**Consultation Response from KC,
Highways Development Management****2021/93621 Land off, Fullwood Drive, Golcar, Huddersfield, HD7 4JH****Erection of 12 dwellings and associated works (Within a Conservation Area)****Date Responded: 29/06/23****Responding Officer: CNB****Responding Ref: K2-3NE/4**

Project No: 2673 Drawing No: (100)03 Rev: 1

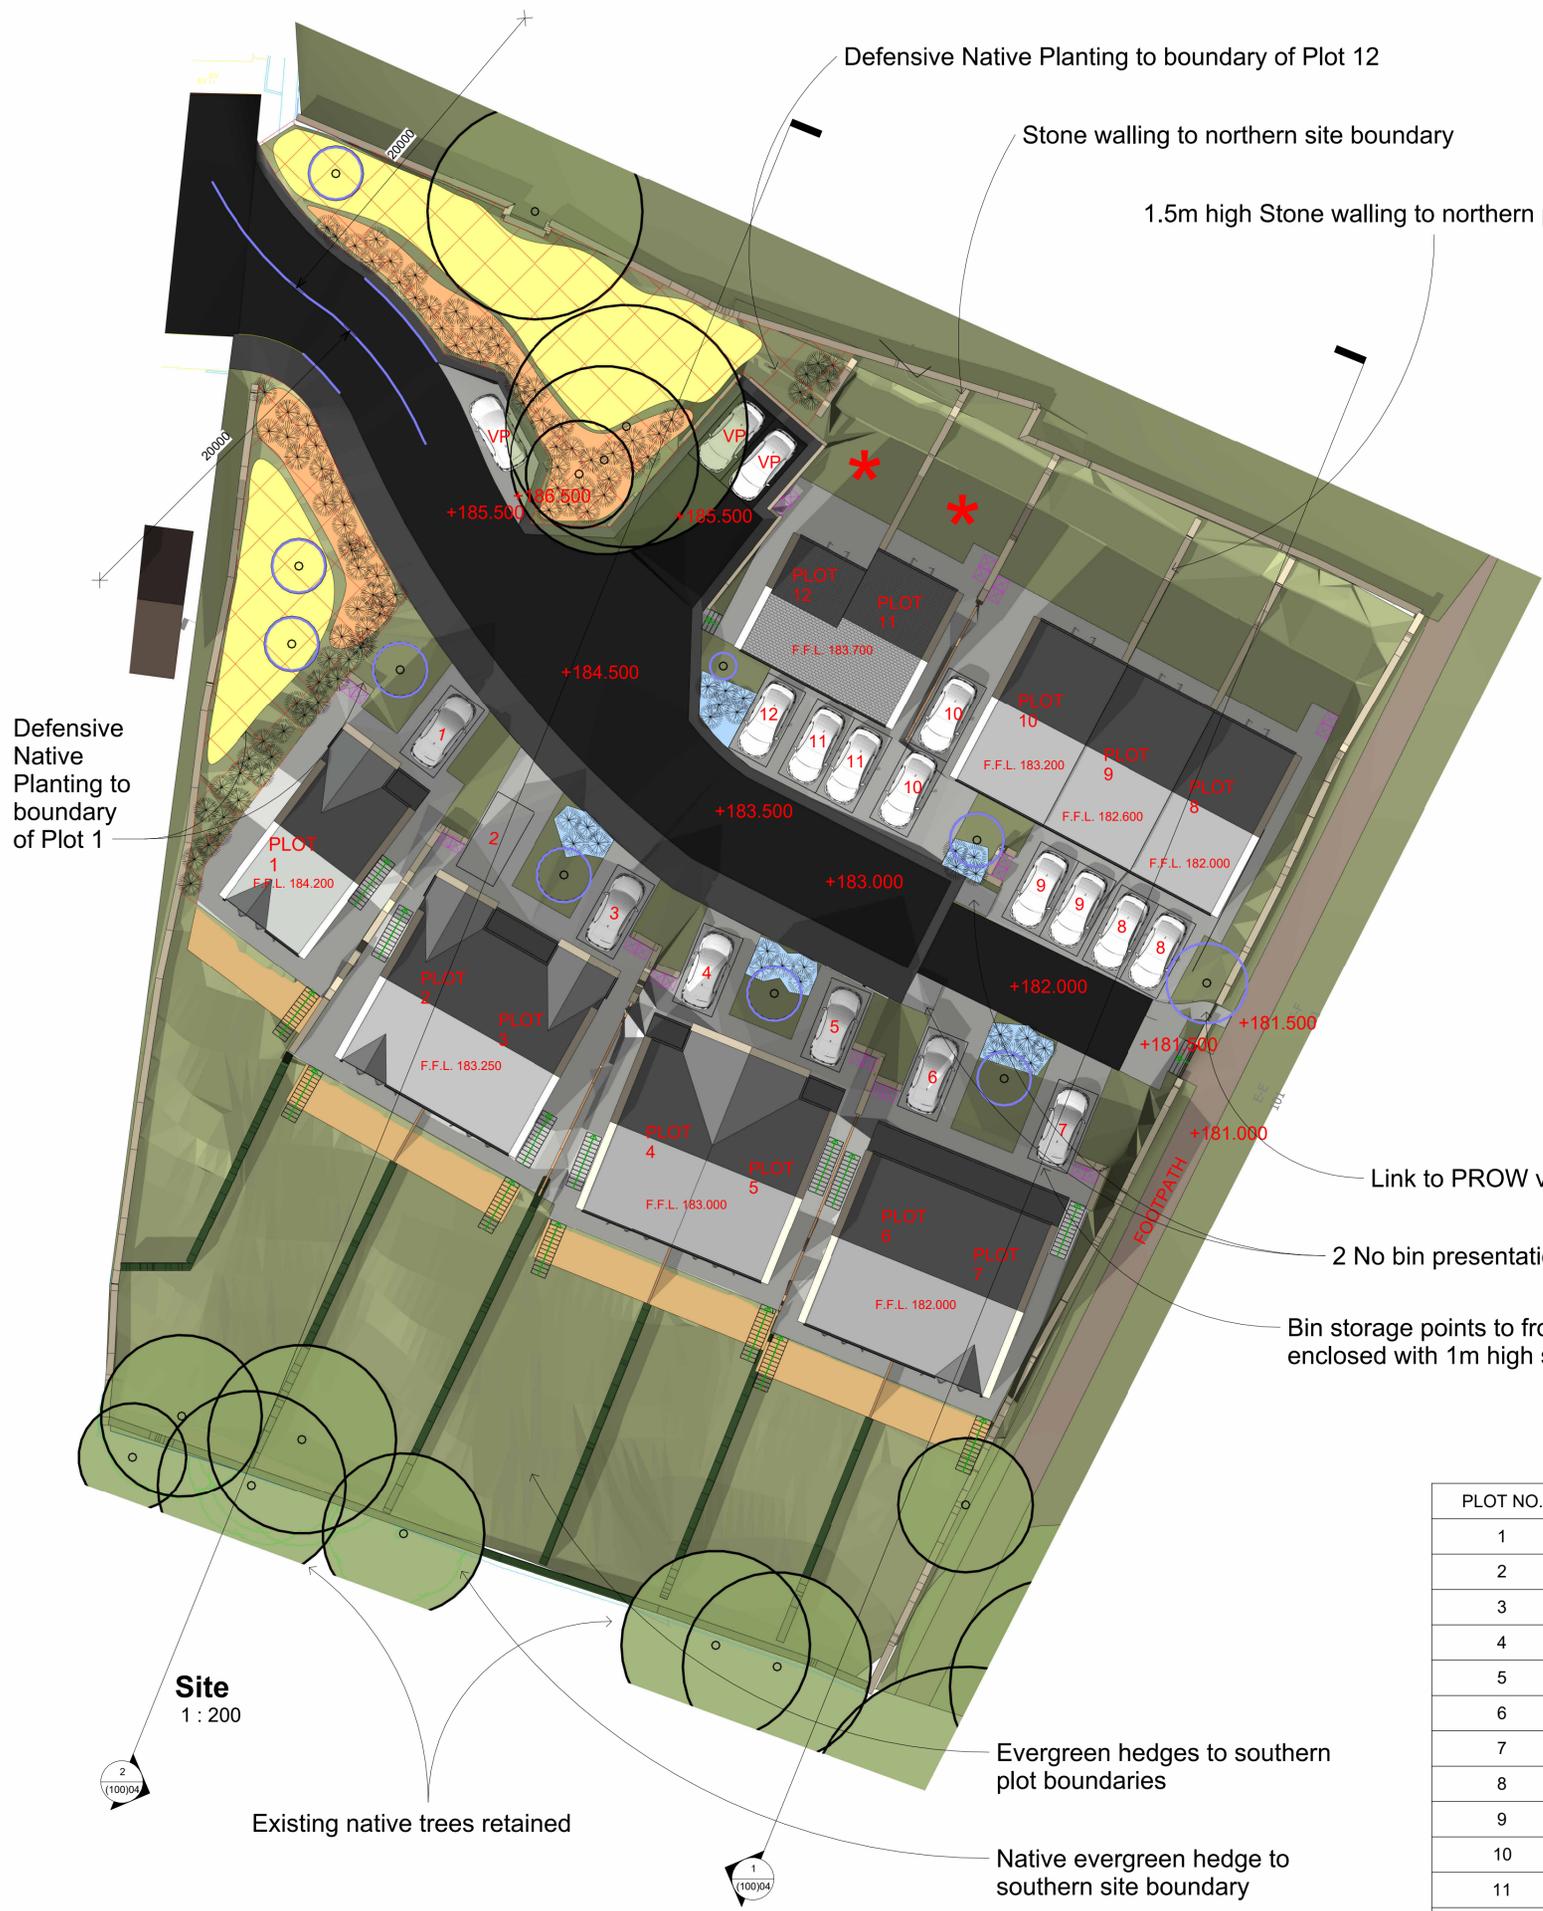
The access road through the site is positioned quite clumsily off the existing turning head and drawing (100)03 Rev E shows it coming off at a dogleg from the existing road, this would be an uncomfortable manoeuvre for larger vehicles such as a refuse truck. We would like to see a smoother transition from the existing highway to the proposed access road. There is also a curve immediately after the junction with the existing turning head and this appears to have a centreline radius greater than that requested in local guidance. It may be desirable to amend the layout of the highway to create a better transition and reduce the initial centre line radius of the first curve. Either way the transition and the access road should be shown to be able to take an 11.22m refuse truck by means of a swept path analysis.

Based on details contained in drawing No (100)03 Rev E and drawing (100)16, the proposals do not appear to adhere to local guidance relating to parking provision especially relating to plots 11 and 12 which appears to have only 1 parking space. The concern is that these dwellings may decide to use the adjacent visitor parking spaces and that would reduce the availability of parking.

The drawings show that there are to be three visitor parking spaces, and this would be acceptable for 12 dwellings, however we have concerns over the two visitor parking spaces to the back of the turning head. In addition to them possibly being used by plots 11 and 12, there may be adoption issues if they are included within the s38 application, and we would recommend that the applicant liaises with the Kirklees s38 team at the earliest opportunity to avoid any issues further on in the process.

Drawing No (100)03 Rev E shows the location of waste storage and collection points, and these are generally acceptable (although please note separate consultation comments from the Kirklees Waste Strategy team), however this would depend on the locations being accessible to a Kirklees refuse truck and this would require submission of the swept path analysis.
